CITY OF ALBUQUERQUE

Re: McDonald's 12th and Indian School, Grading and Drainage Plan
Engineer's Stamp Date 5-17-13 (H09/D009)

POST DEVELOPED DRAINAGE PLAN  
SEC OF 12TH ST. & INDIAN SCHOOL RD., ALBUQUERQUE, NM

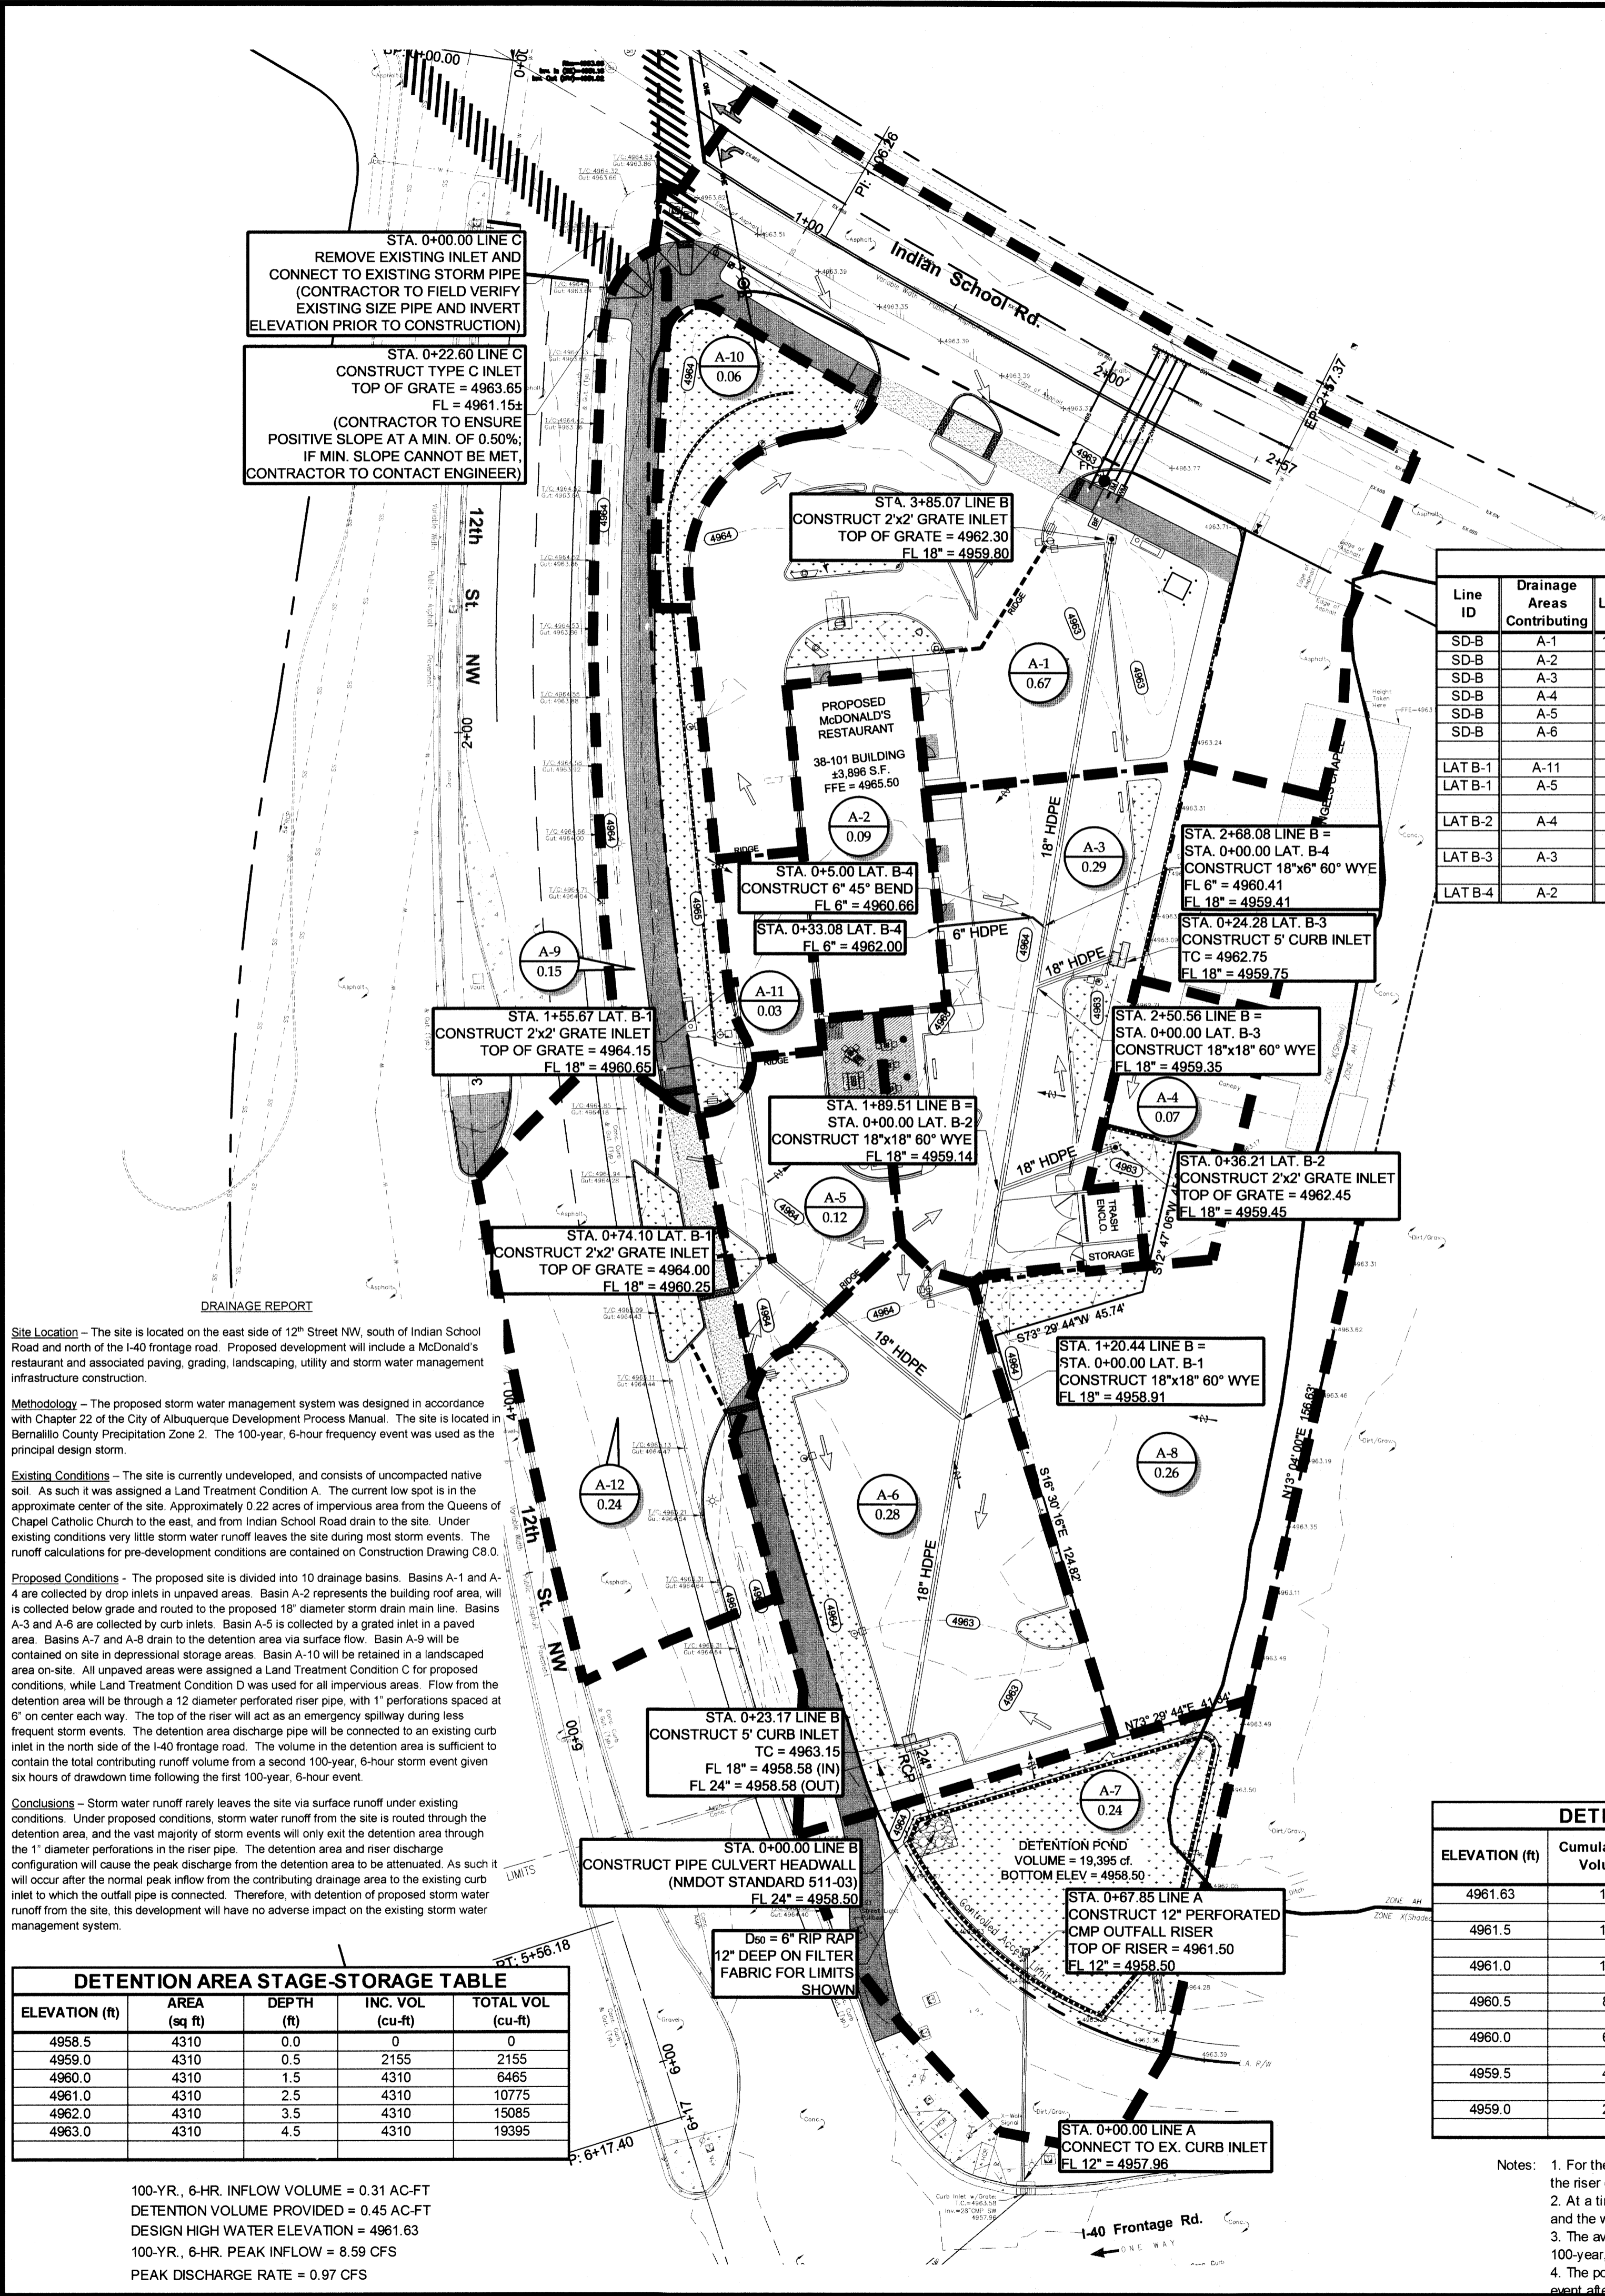
1. Show an adequate water-block on 12th St., to prevent flows in 12th st. from entering the site.
2. Provide riser construction details.
3. Show the onsite storm drains on Sheet C7.0.
3. Existing grades were difficult to read on Sheet 7.0, due to them being too light.
4. The architect may have to build a speed hump from the pedestrian access on 12th St. to the patio area, which may interfere with draining Basin A5.
5. A Floodplain Development Permit is required for Building Permit approval, due to the AH Zone. Please contact Hydrology if you wish to learn more about this process.
